Subject: FW: BR/315/19/PL, 98-100 Chichester Road

In relation to the above site addresses Full Planning Application, seeking approval for a new first floor flat above the existing ground floor office and following receipt of your previous email, please find attached a series of revised drawings which remove the previously proposed half hip ending for the extended section of roof.

PROPOSED FRONT ELEVATION

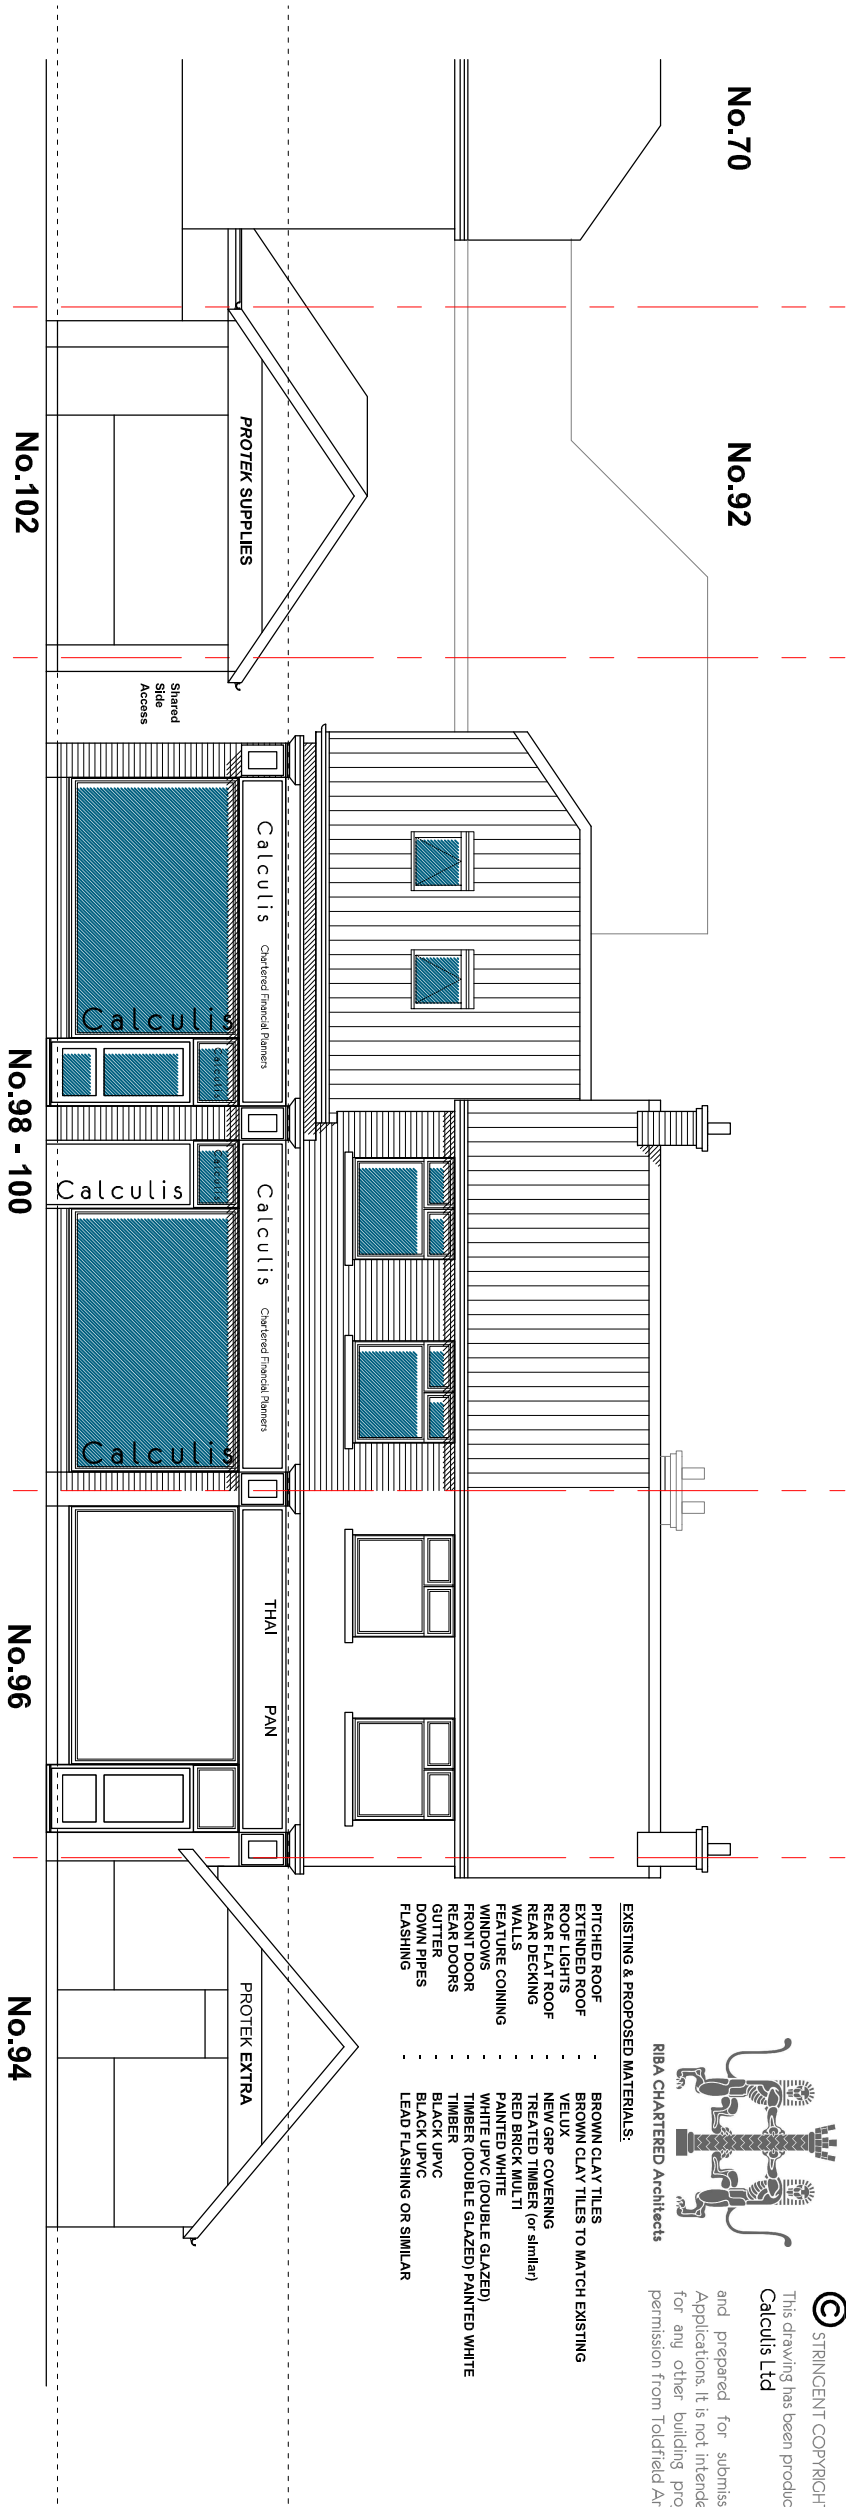
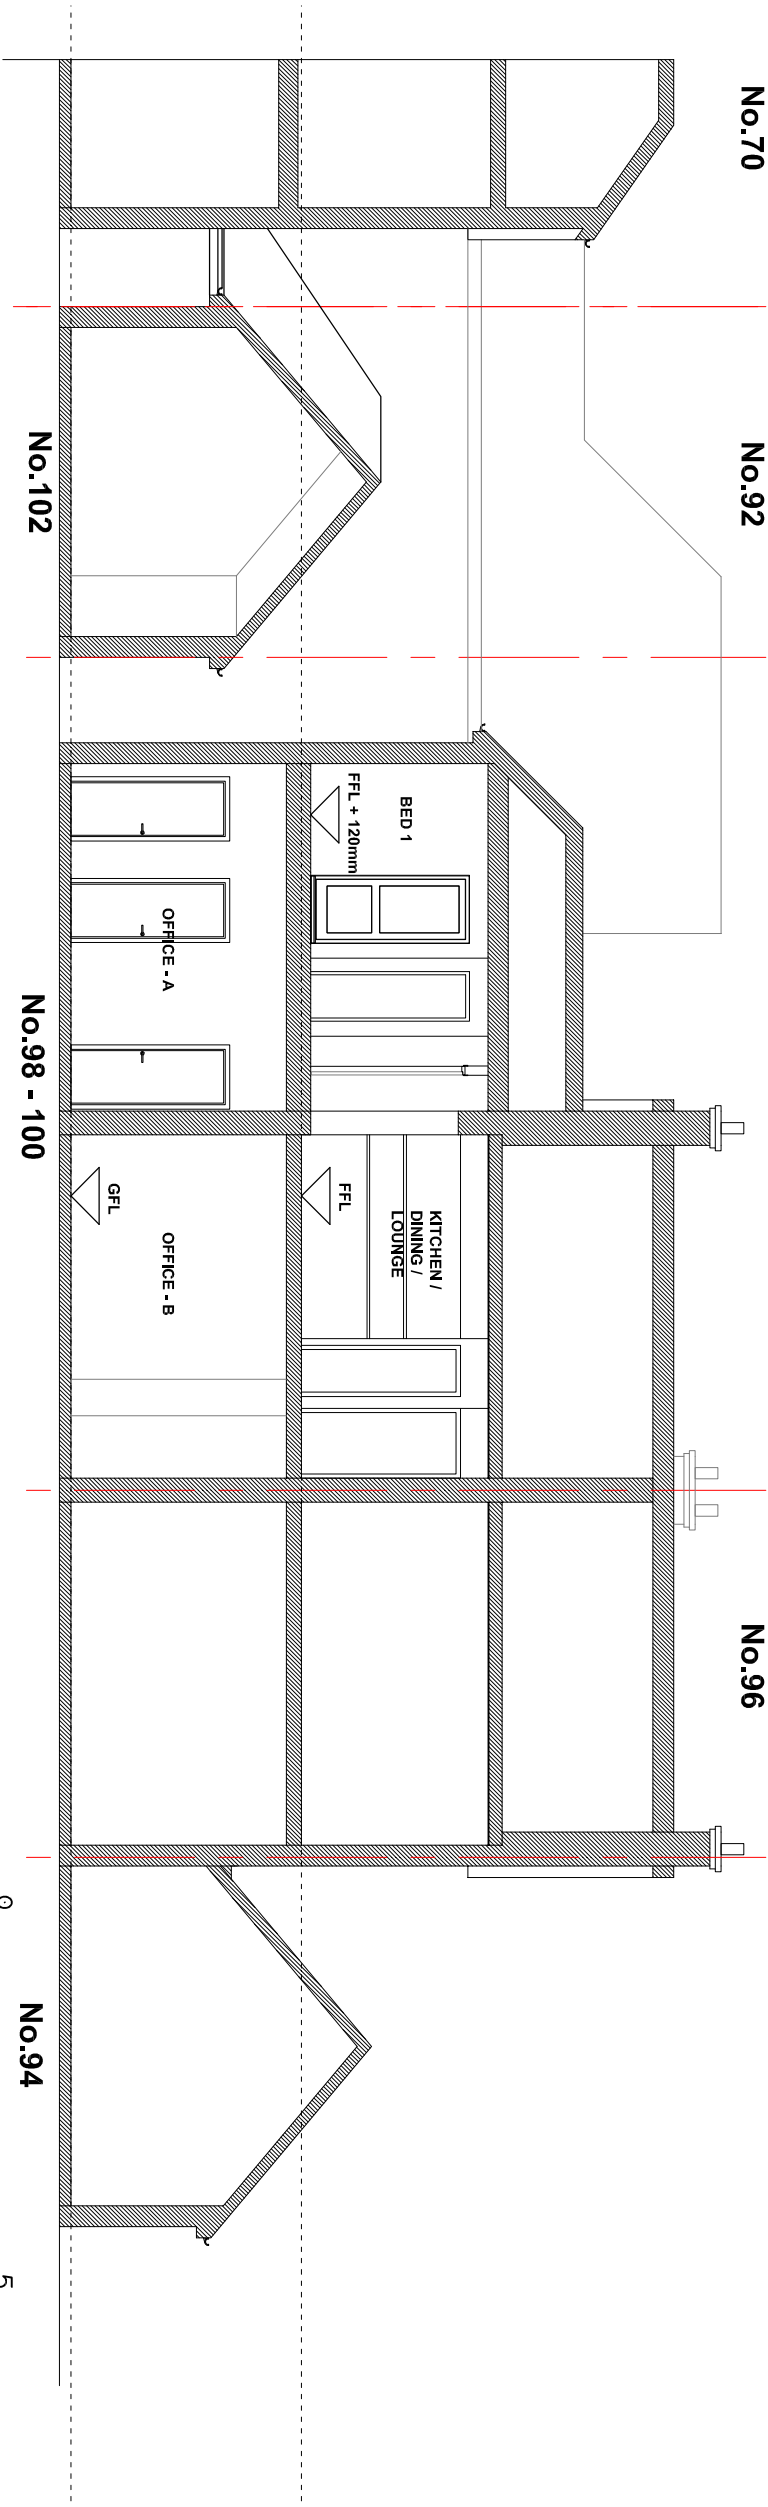
As a planning officer of this case I would like to advise you to change the proposed half-hipped ending of the extended roof to the gabled. I do understand your intension, however in this case it is unnecessary to copy what is to the right since the proposal property is a part of terrace with gabled ending.
